Online Comment

Application H11-0730-20
Location Pear Tree Farm St James Road Long Sutton PE12 9BA
Proposal New dwelling - approved under H11-0245-18. Modification of Condition 2 to allow amendments to previously approved plans

Name Jeanette Reith
Address Environmental Protection - South Holland District Council

Drawing
Landscape Layout

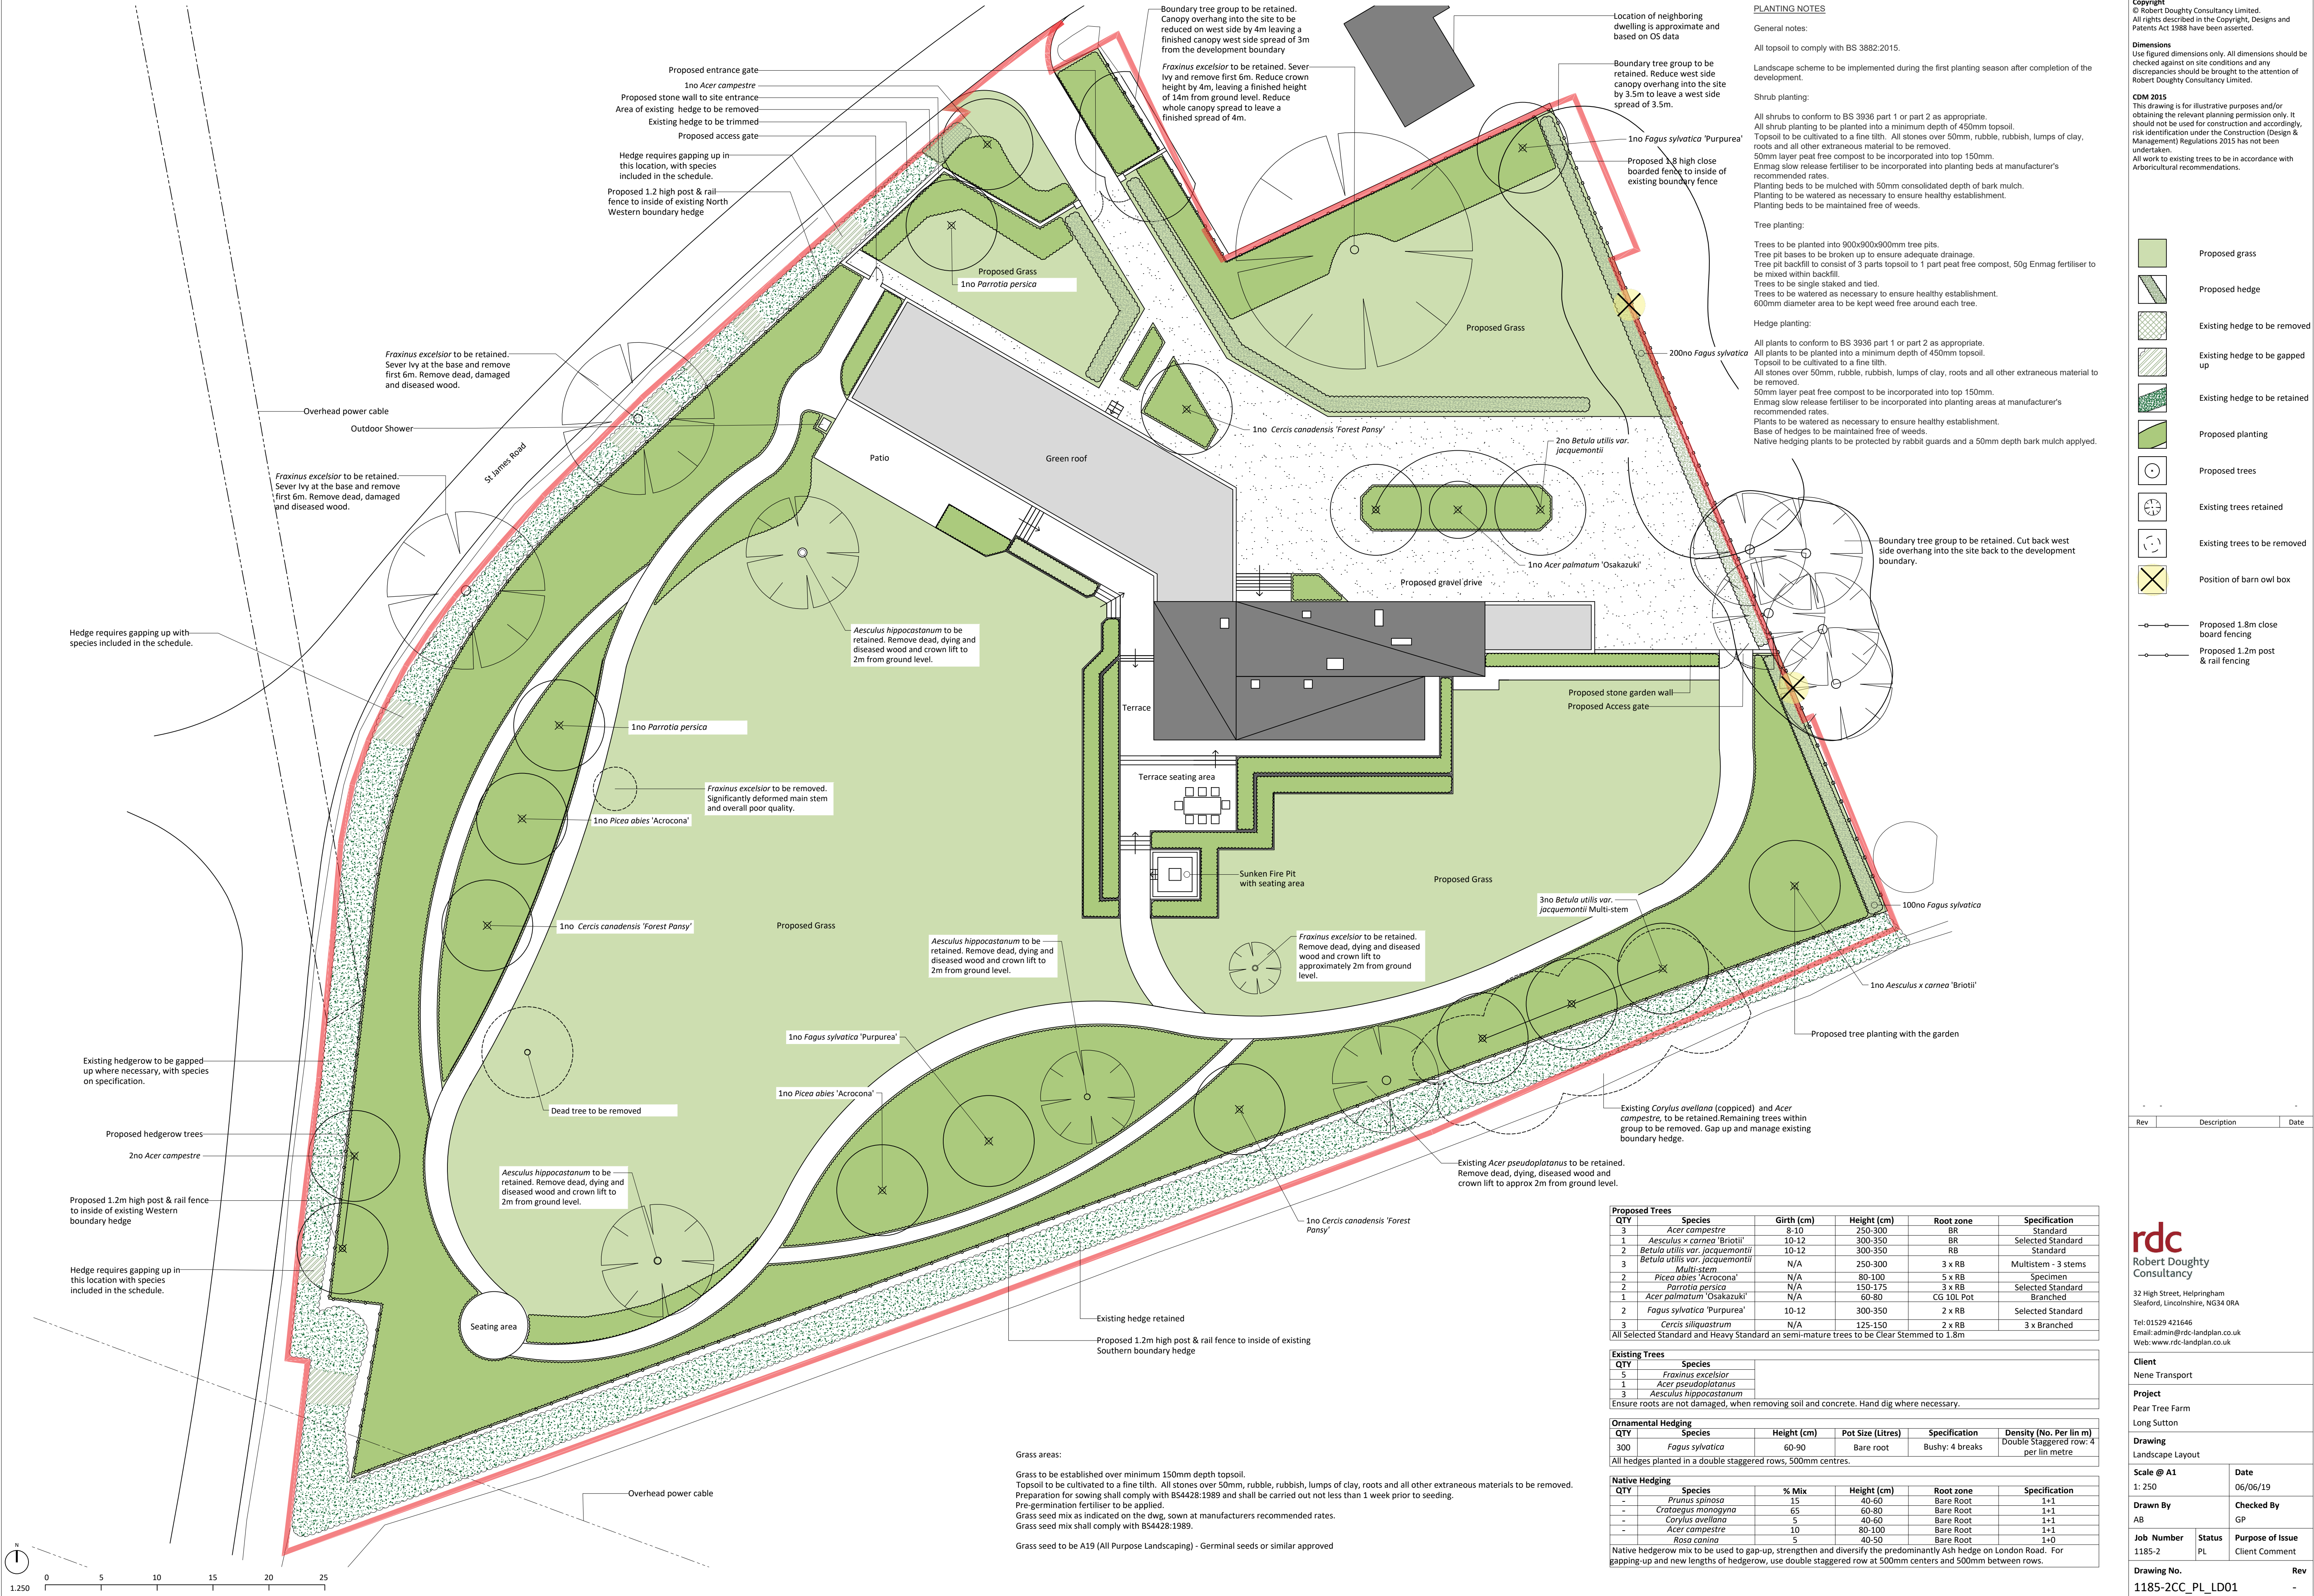
I would also like further clarification on the extent of the garden/landscape areas that will require a clean cover system (preferably on a site plan). I note that hydrocarbon odours were recorded in the dynamic sampler logs by Delta-Simons in locations DS101, DS104 and DS105.
